REQUEST

Current Zoning: N1-A (Neighborhood 1-A) and ML-1 (Manufacturing & Logistics-1)
Proposed Zoning: N2-A(CD) (Neighborhood 2-A, conditional)

Approximately 8.74 acres located on the south side of Mount Holly Road, west of Rhyne Road, and east of Creston Circle.

The petition proposes the development of up to ~~100~~ 90 multi-family attached dwelling units. The site is currently developed with three single-family houses.

SHEET NO.
RZ-1.00

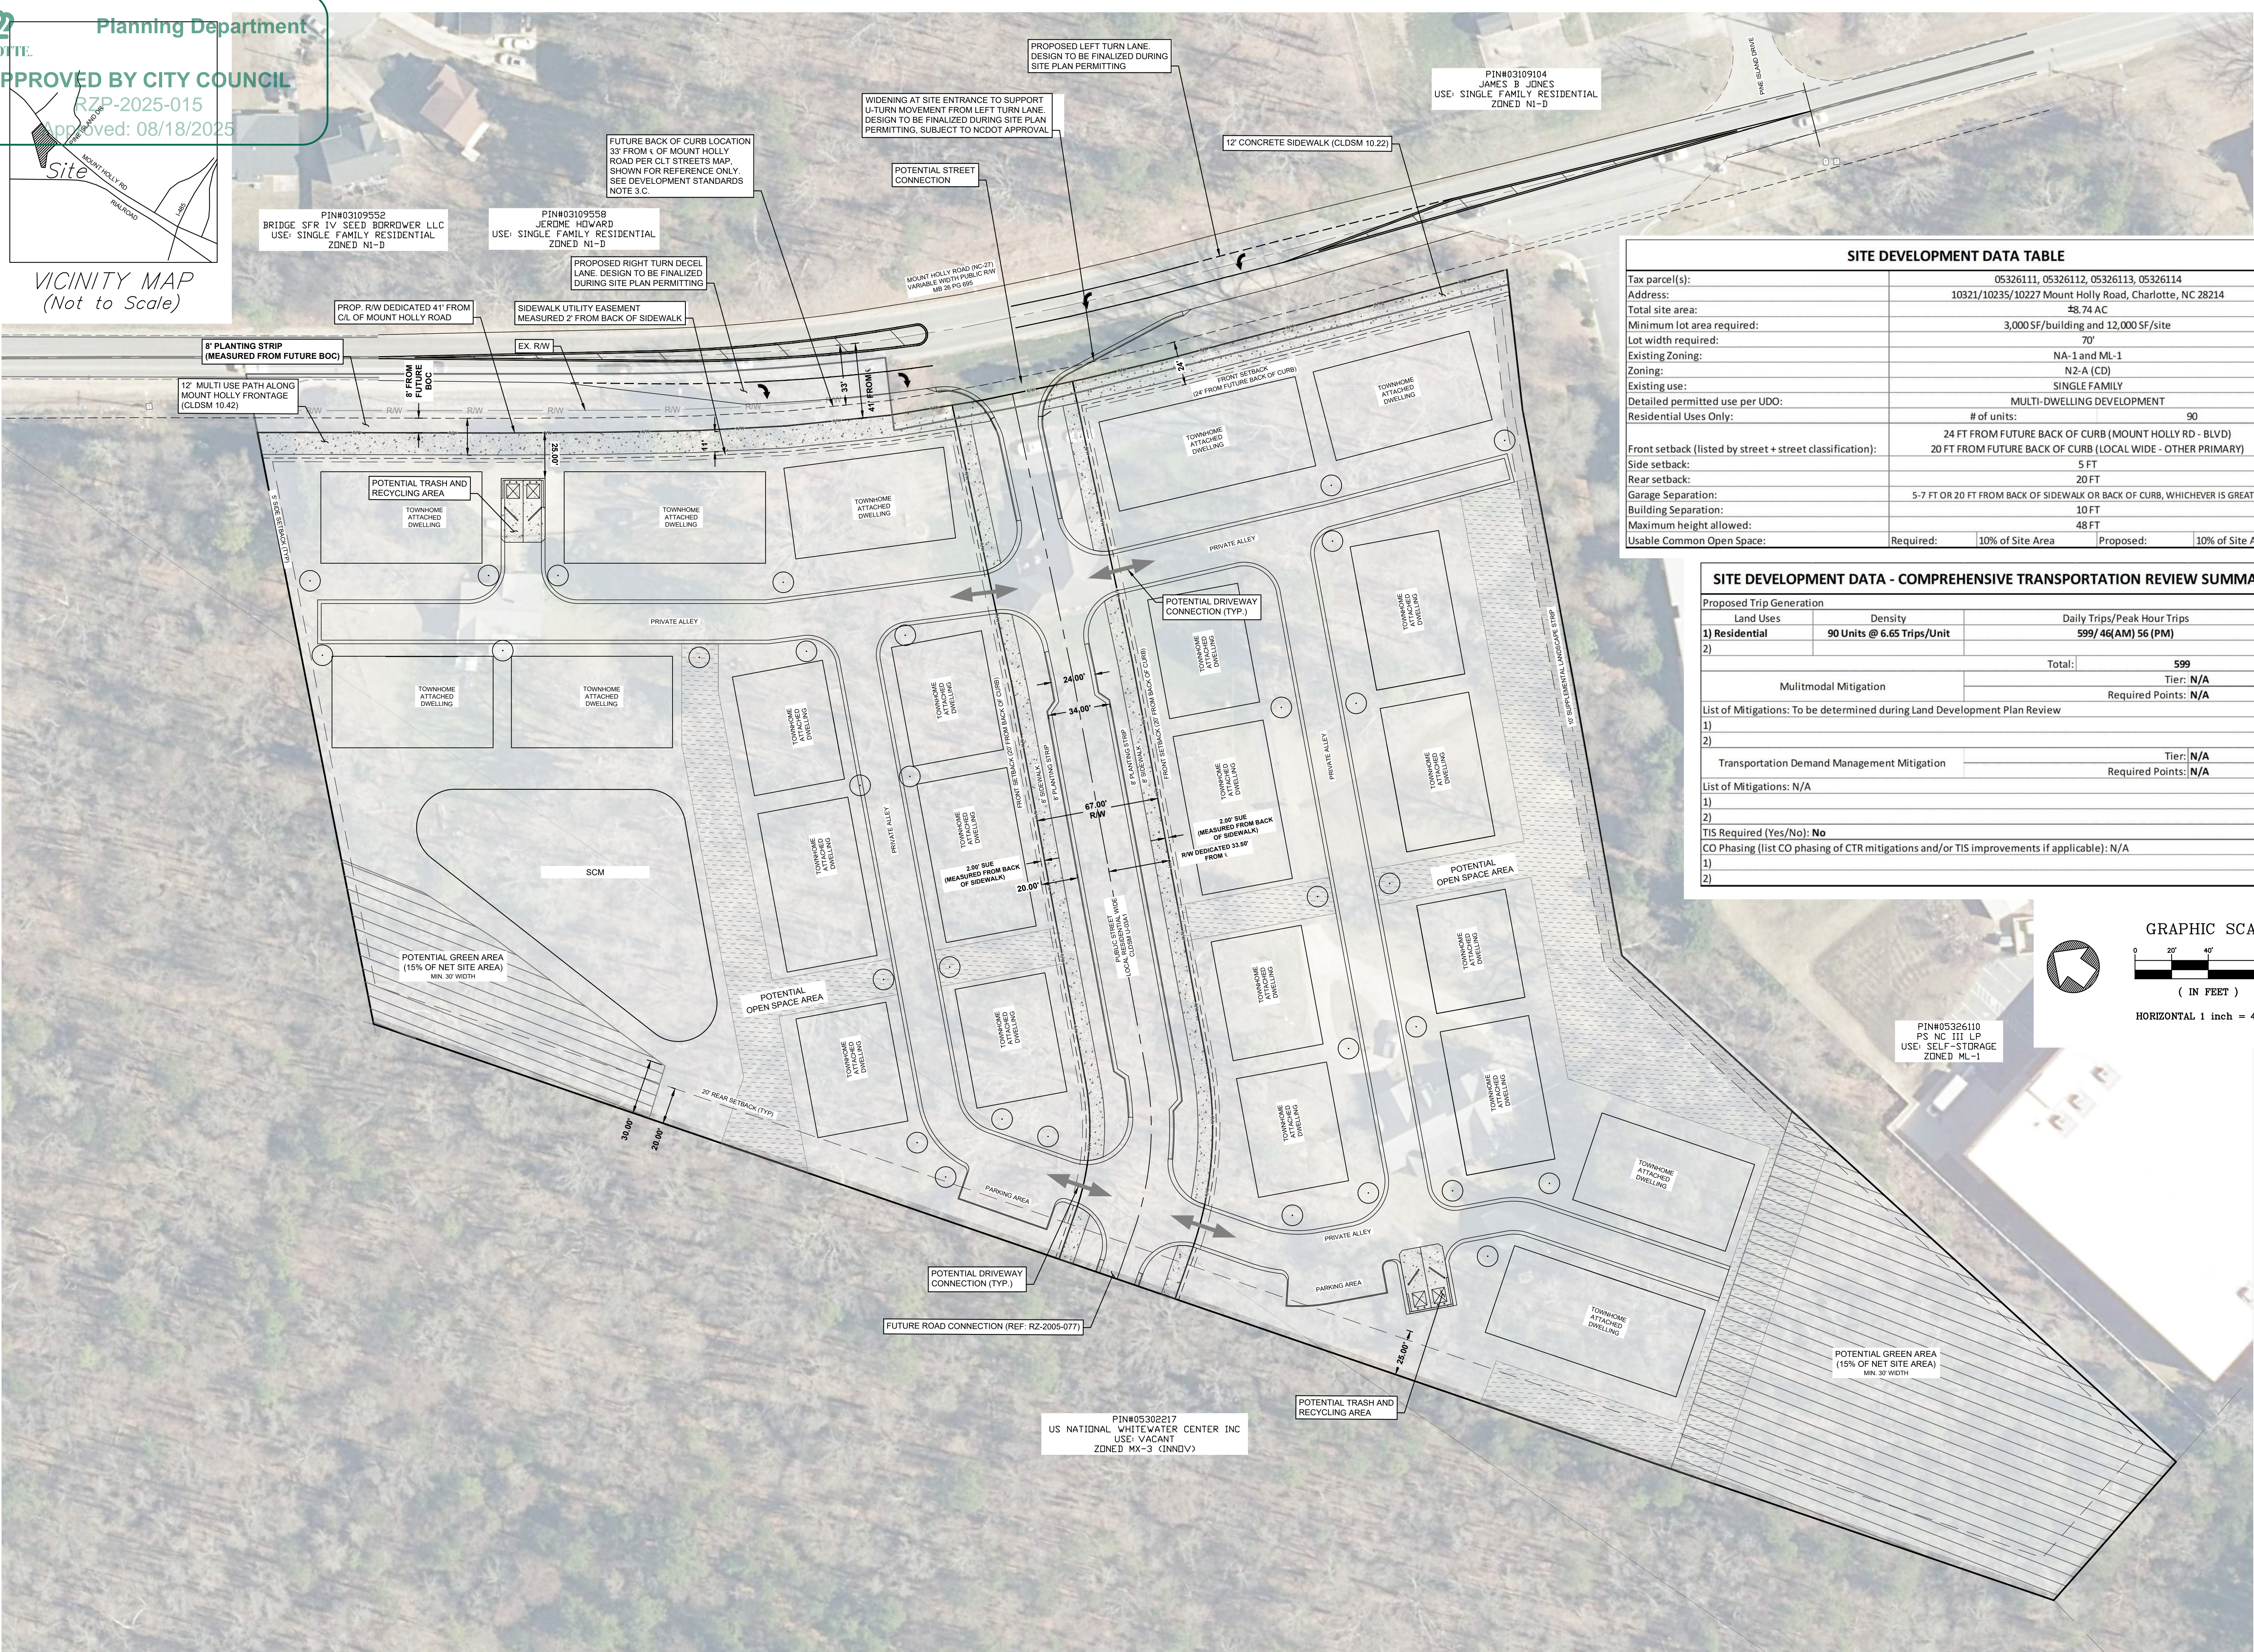
1. Entitlement Services: ~~Number of units per building should be limited to 5. A commitment to a minimum proportion of duplex, triplex, and quadruplex buildings should be made.~~ Addressed
2. Entitlement Services: ~~The amount of open space internal to the site should be increased and the arrangement of open space should be updated to so that more buildings front on usable open space.~~ Addressed

- Permits the development of up to ~~100~~ 90 multi-family attached dwelling units.
- The following transportation, streetscape, and landscaping improvements are proposed:

- Buildings shall contain a maximum of ~~6~~ 5 dwelling units. ~~With no more than 3-6 unit buildings constructed on site. Buildings fronting Mount Holly Road will be restricted to 4 and 5 units. A minimum of 6 buildings on site will be triplexes.~~
